## TECHNICAL NOTE

Reference: P0421t06v01

### **Revised Response to Submissions Ivanhoe Estate, Macquarie Park (SSD 8707)**

Figure 3: Herring Road and Ivanhoe Place intersection

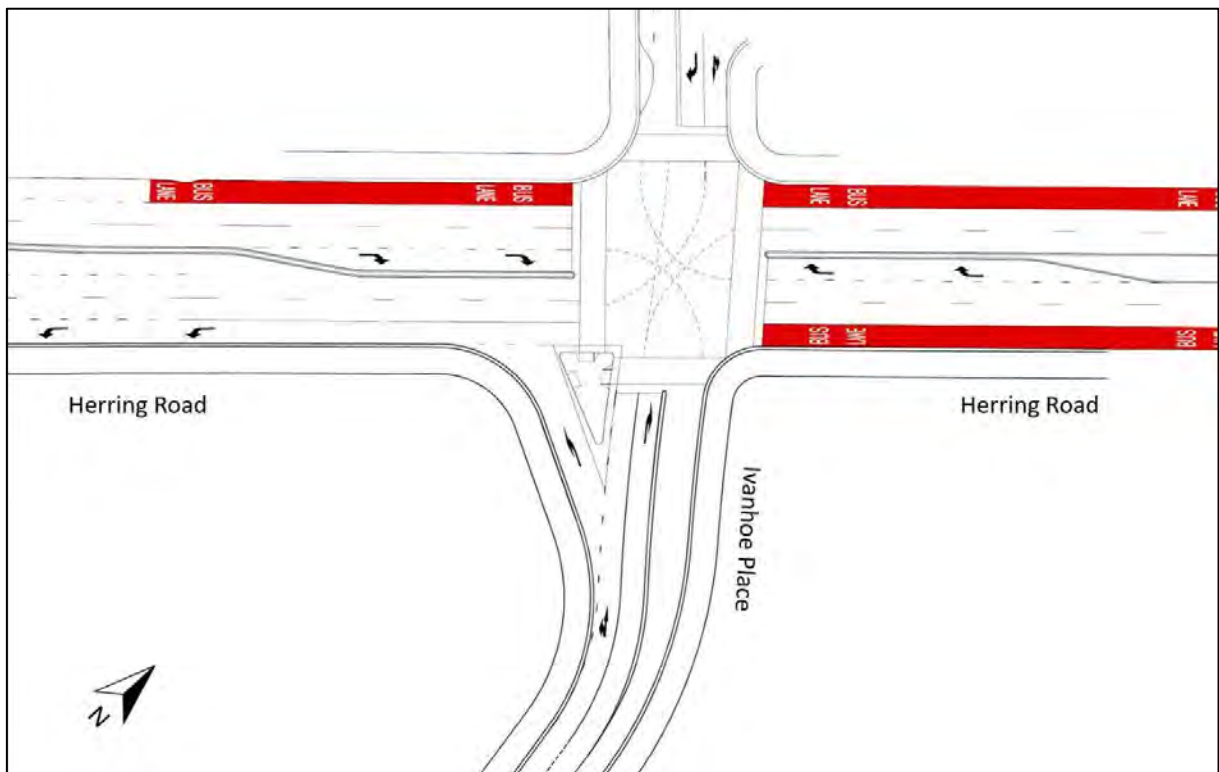
*The 100% concept design for the Stage 2 - Bus Priority and Capacity Improvements Project indicated that the right turn bay storage on Herring Road at Ivanhoe Place intersection will be approximately 20-25m in length, which could accommodate about 4 vehicles. Information provided on the Technical Note dated*

9/10/19 is not sufficient to determine whether the right turn bay has sufficient capacity to accommodate the right turn demand without impacting on the through lane. Given that Herring Road /Ivanhoe Place intersection will be the main access for the precinct, this issue must be resolved prior to determination of the development.

It should be noted that the analysis demonstrates that an approximately 20-25 metre right turn storage bay from Herring Road to Ivanhoe Place—accommodating approximately 4 vehicles—as specified in the 100% concept design for the Stage 2 - Bus Priority and Capacity Improvements Project, would not be sufficient. However, all of the modelling to date for the Proposal has used a 35 metre right turn lane as advised by RMS and provided in their Aimsun model.

Further, the maximum queue forecast for the 2031 scenario of 60 metres does not spill back to the Epping Road intersection. However, it is expected that further analysis will be conducted by TfNSW during the design phases of the signalised intersection using updated survey data to more accurately determine the required storage with consideration of the many recent network changes.

Figure 4: Proposed left-in access from Epping Road to the Site

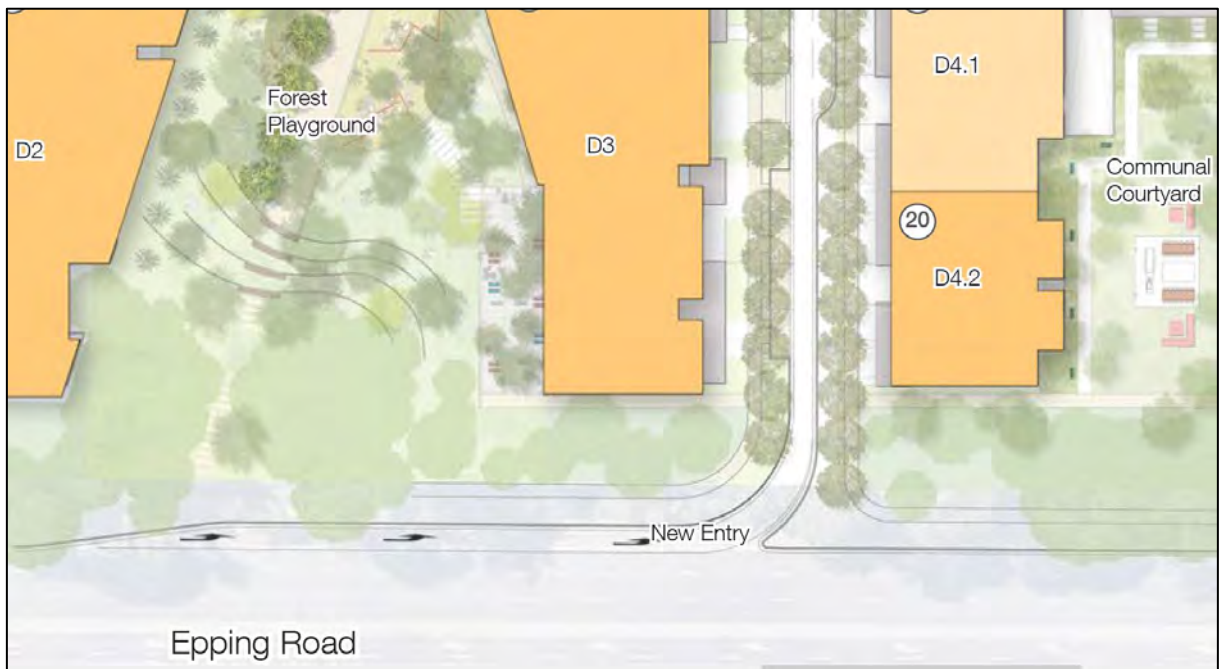
*The deletion of the slip lane may have adverse traffic implications. However, it does result in the protection of additional trees. Re-distribution of traffic due to the removal of the slip lane must be considered. Whilst the Technical Note dated 9/10/19 provided the intersection results for with and without the Epping Road slip lane option, detailed intersection results must be provided.*

Since the decision to remove the left-in slip lane, a SIDRA analysis has been undertaken of the network shown in **Figure 1** to examine the future operation of the key intersections within the study area following redistribution of traffic.

As shown above, with the exception of Epping Road x Herring Road, all other intersections would operate with acceptable LoS in each peak. The QSR values indicate that average queue length would not spill back to any upstream intersections.

The results indicate marginally higher delays and longer queues in each intersection. Generally, each intersection would continue to perform with LoS similar to 2021.
